IP [REDACTED]

Andrew McDonald

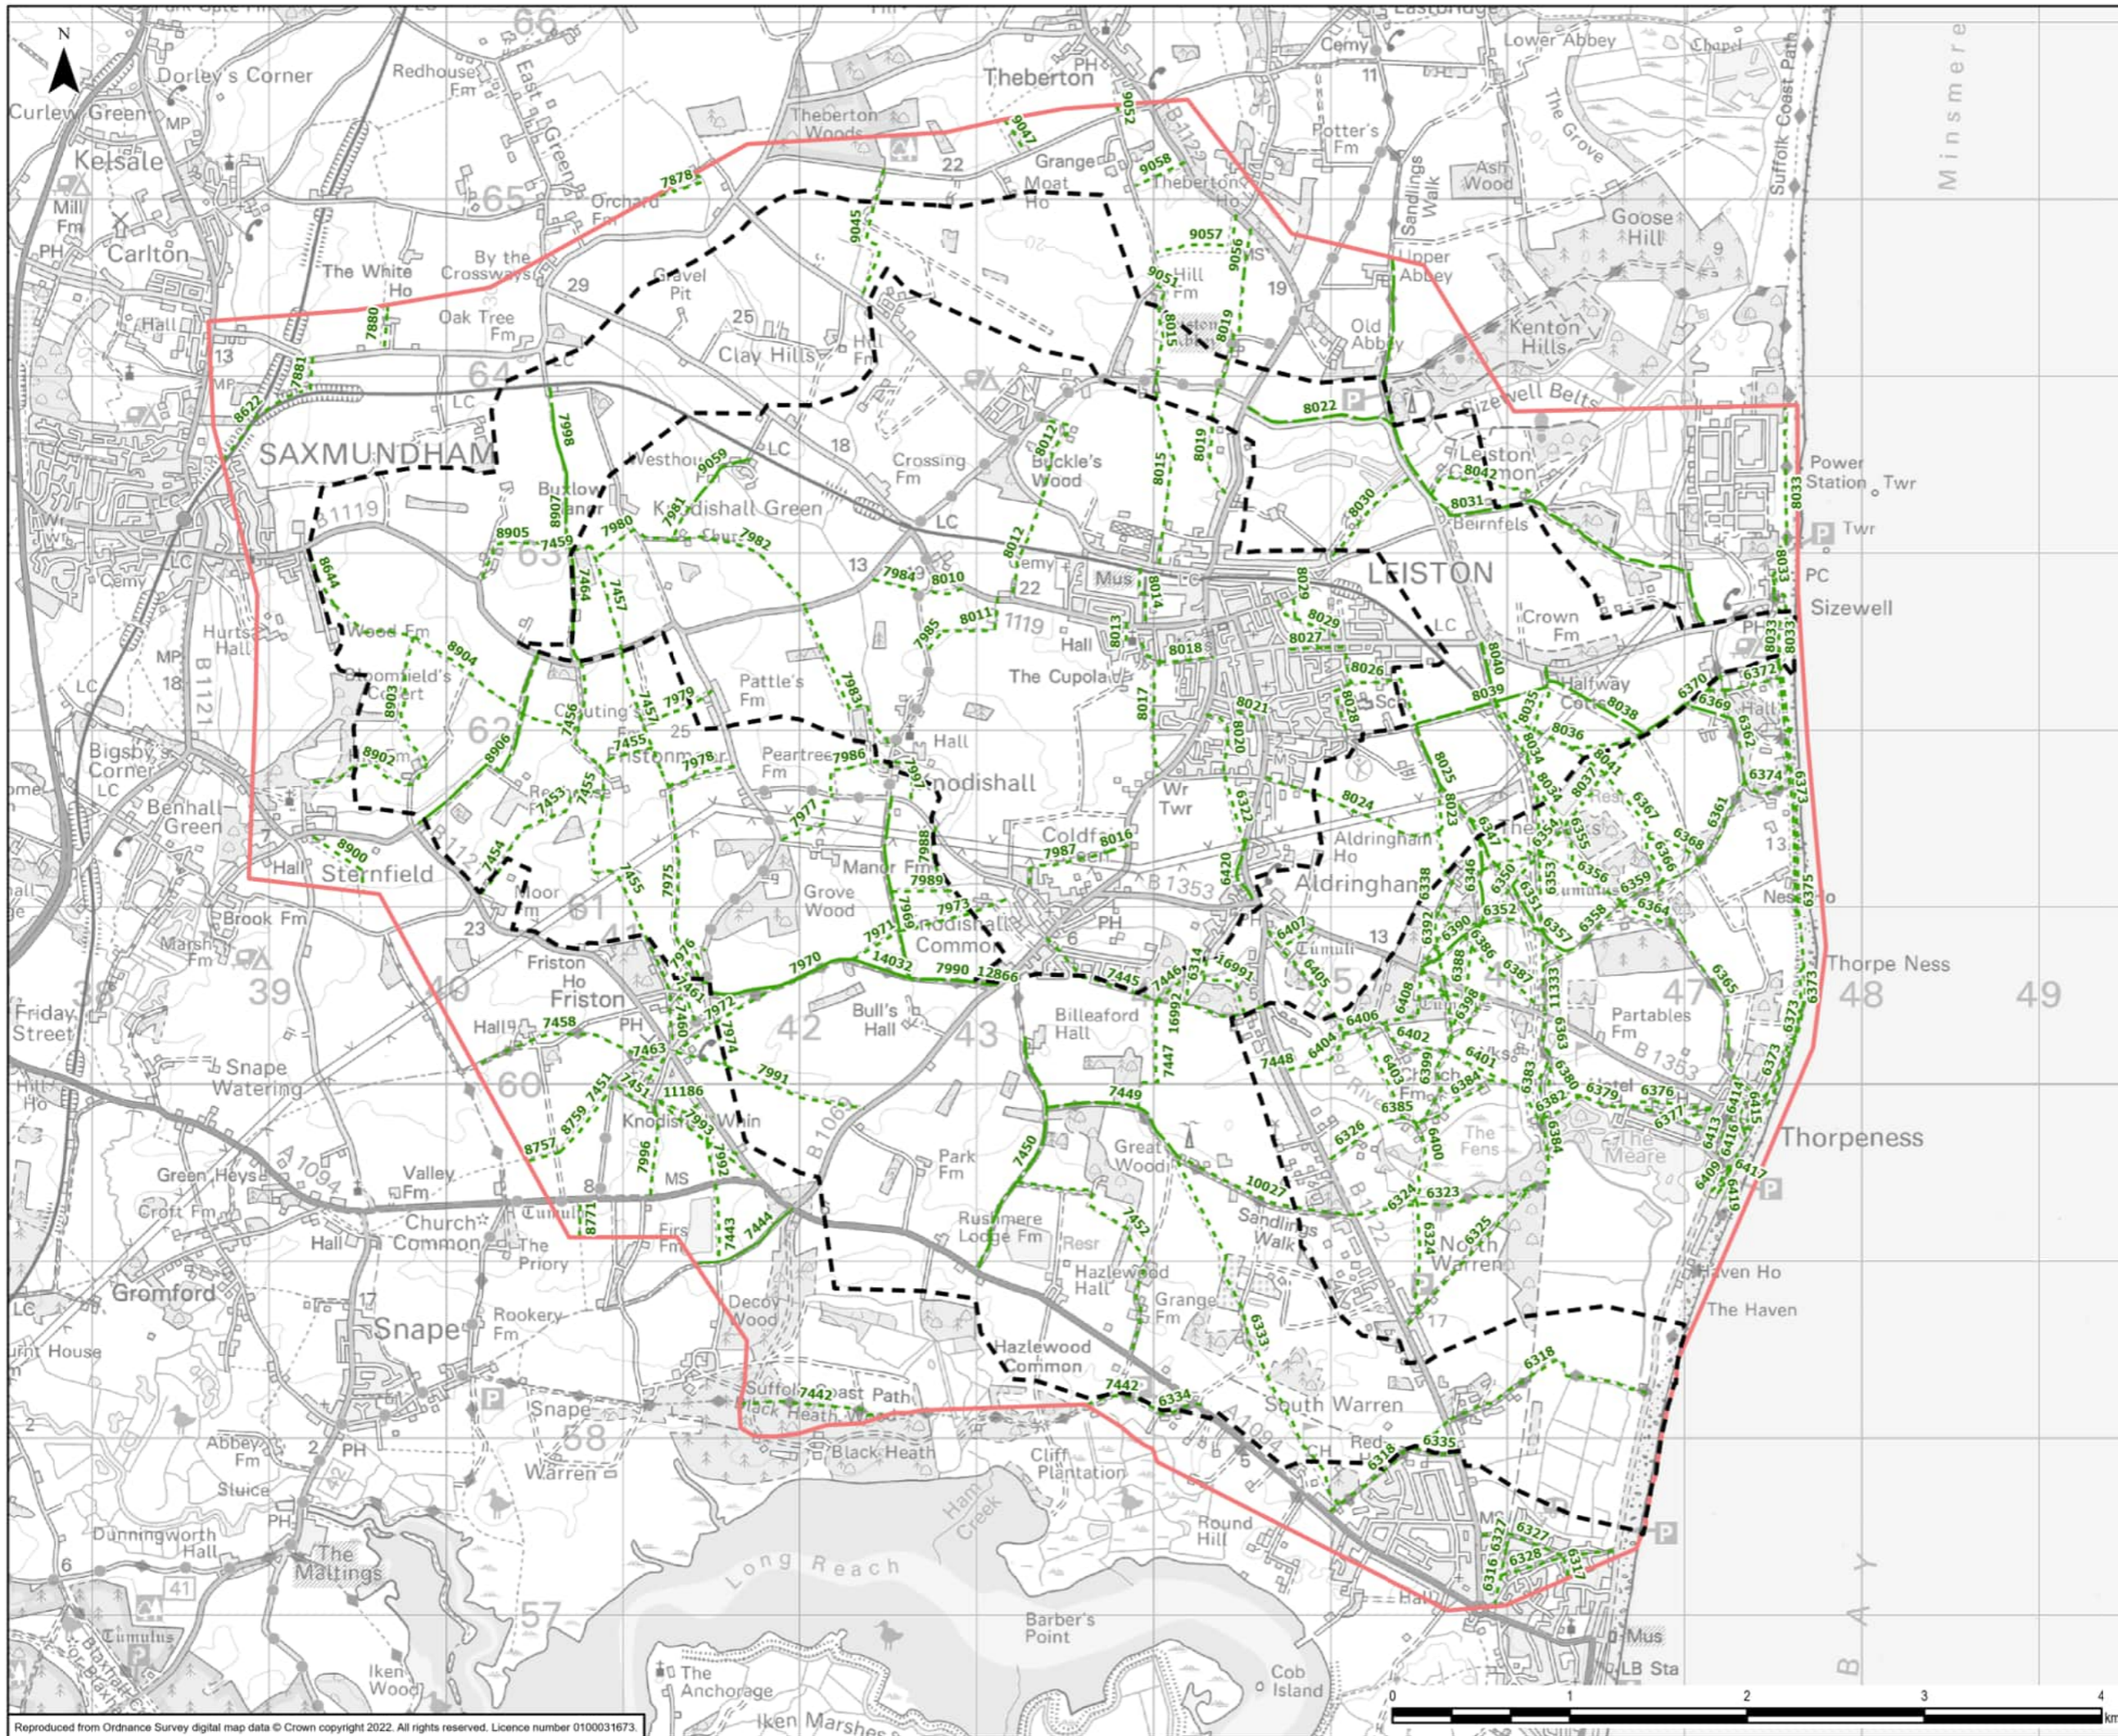
1 I have previously made written and oral submissions on cumulative traffic management and impact pressures, especially in respect of the limited choice of study area that NGET have chosen; and also in about their expressed lack of concern for traffic pressures consequent upon the addition of SeaLink traffic to SPR/SZC/LionLink *outside* that area. Road users (as they are now demonstrating) are quick to respond to danger and delay on their present routes by finding alternatives, and this should have been part of NGET's forecast and assessment processes.

4 In projects of this scale it is more usual to use **junction modelling** than magical means to ensure that infrastructure can handle future demand while minimizing congestion. It is a critical component of transport assessments, and so I'd like to just ask **why Sea Link's proposals are being examined without a full traffic assessment**; and with junction modelling squeezed out, like blood from a stone, from this immensely well resourced and very large company at the last possible deadline?
